APPAHD CONST 10-23-98 - Jan 99

**Re:** Alternative Pedestrian Light Pole  
footings for Arapaho Streetscape  
Project

Re: Arapaho Rd - Pedestrian Light Bases

TYPICAL QUORUM SIDEWALK PLAN DETAIL (A)  
 1/2" = 1'-0"

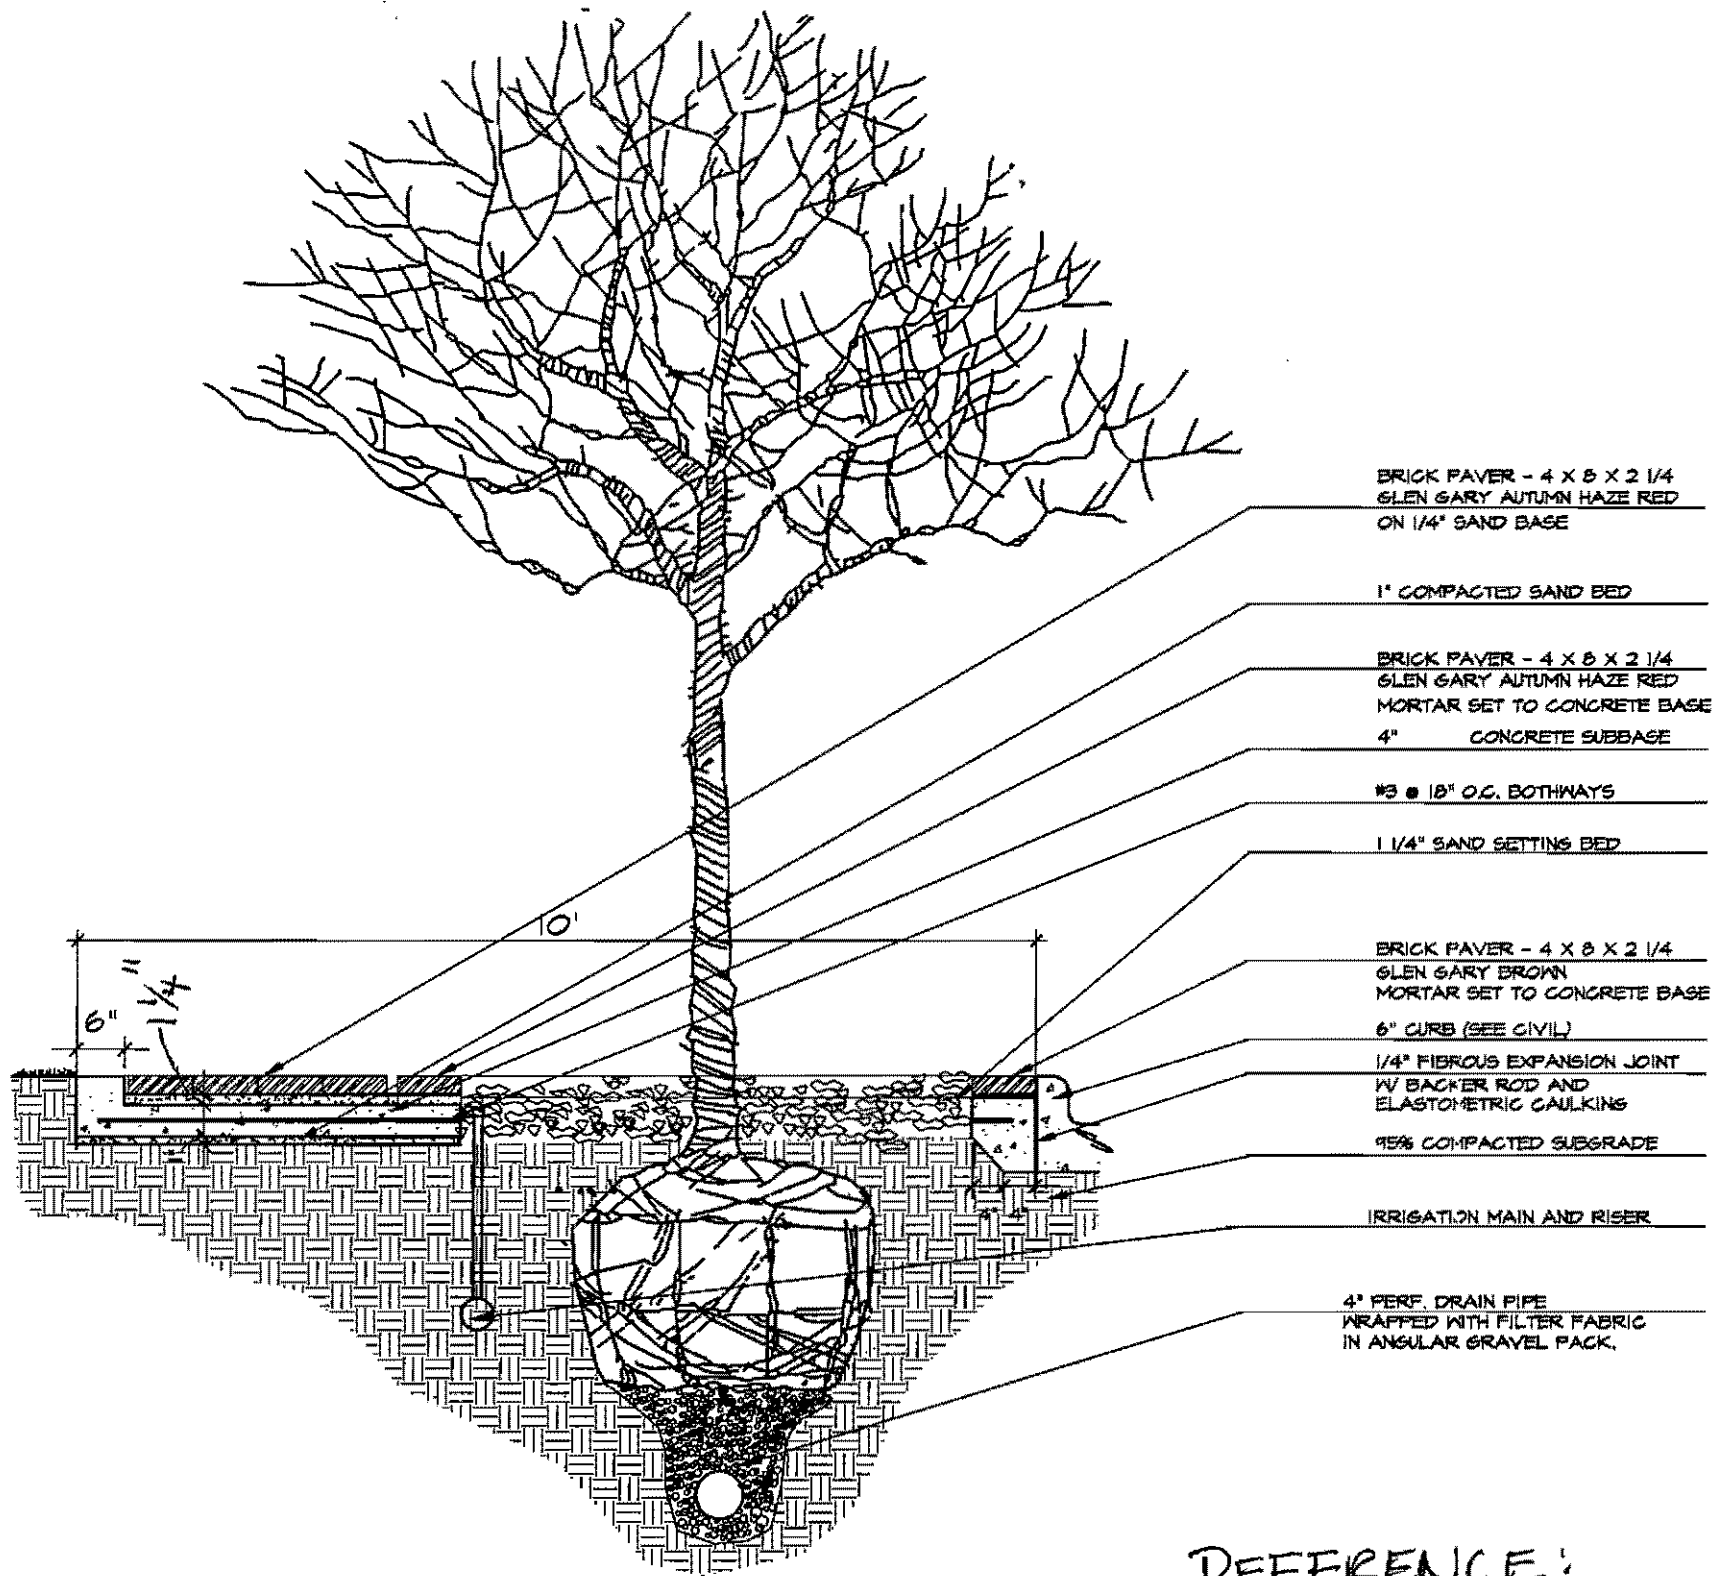
Here are the two light pole footing options for your review. There is a design conflict in the streetscape plans concerning the location and alignment of the Bega pedestrian light footings in relation to the tree well drain line. The plans call for placing the drain and the light pole footing in the same alignment, thus, the 5' deep footing will interfere with the drain line, which is approximately 4' deep.
